SCOTT M MCGEE PE, LLC
CIVIL ENGINEER

RE: Albuquerque School of Excellence – Remodel
13201 Lomas Blvd NE, Albuquerque, NM 87112
(J-22/D050)
Building Permit NO. 201691547

Final Certificate of Occupancy

By: SMM/CB	Sheet: Of:
File:	C-101

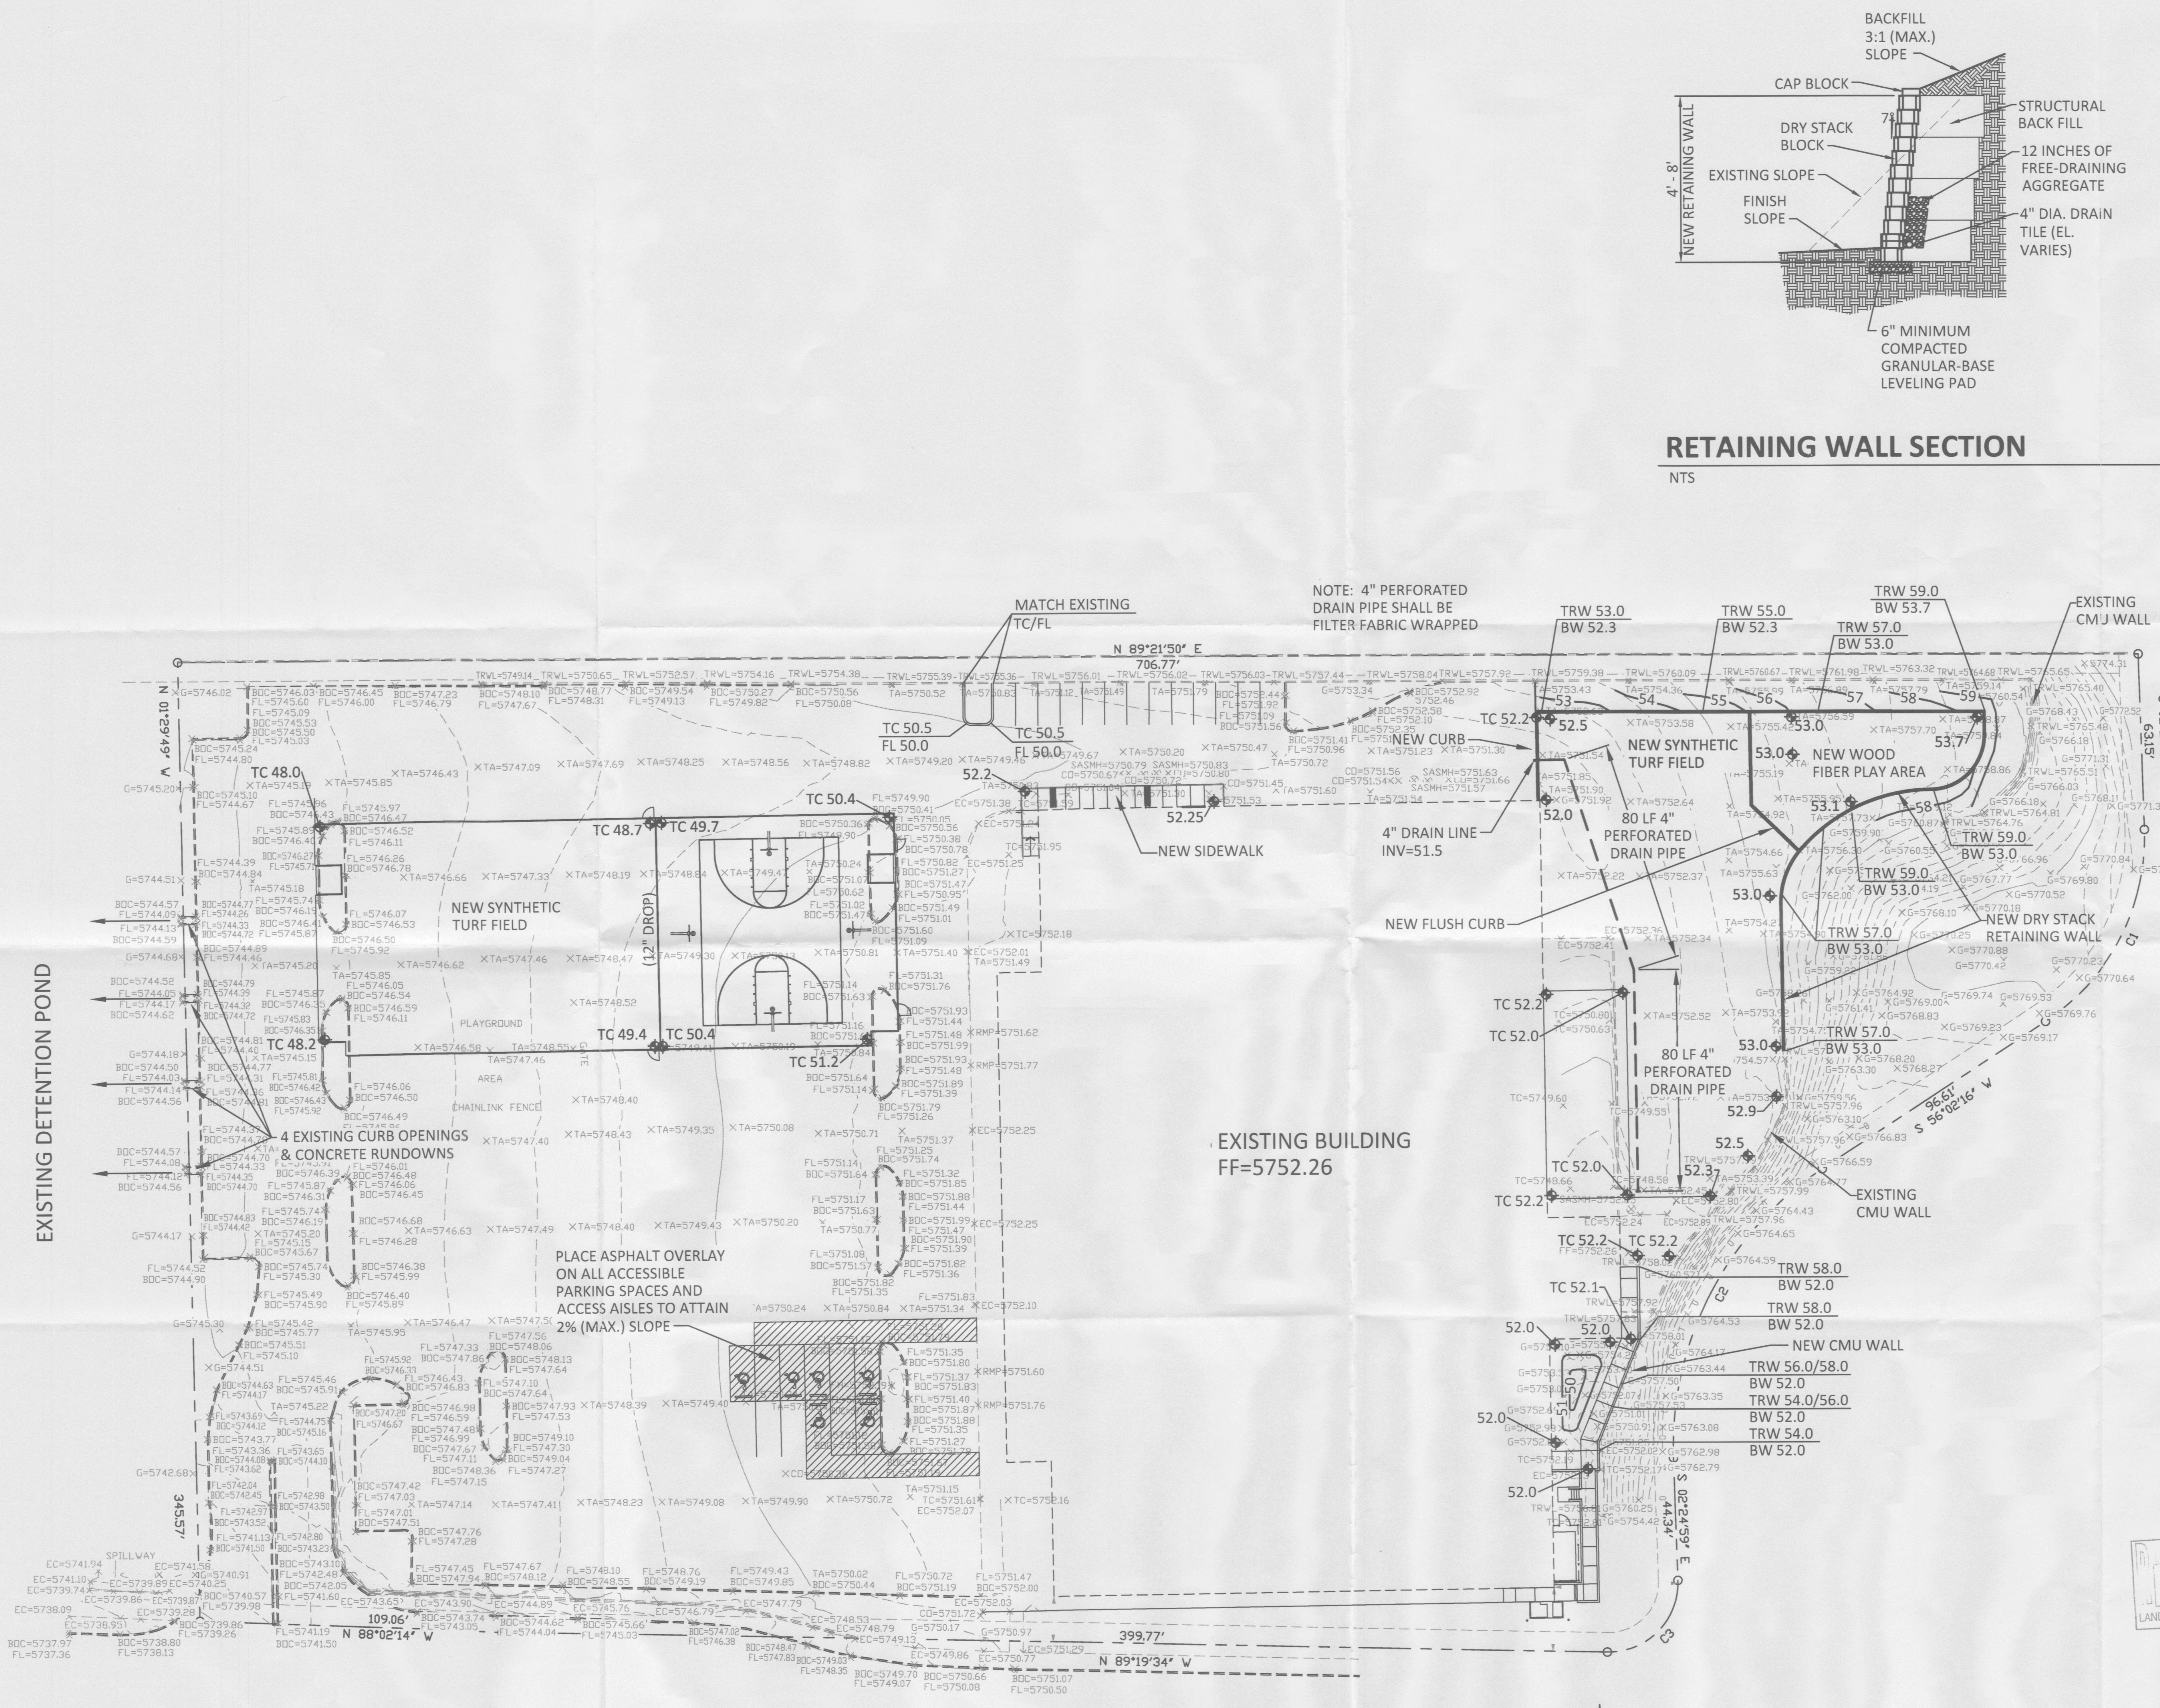
The Owner of the project referenced above has decided to not perform some of the Site Improvements on the project as described and illustrated in the Drawings and on the Grading and Drainage Plan, Sheet C-101.

The playground/recreation areas on the west side of the building (within the parking lot) and on the east side of the building will not be constructed at this time. The asphalt areas will remain as is.

These items were redlined in the City and General Contractor's Permit Sets.

Therefore, as suggested by Monica Ortiz, we are requesting to withdraw the Grading and Drainage Plan from the Permit Set for a Final Certificate of Occupancy, and therefore request the withdrawal of Hydrology Review as a condition of approval for Final Certificate of Occupancy.
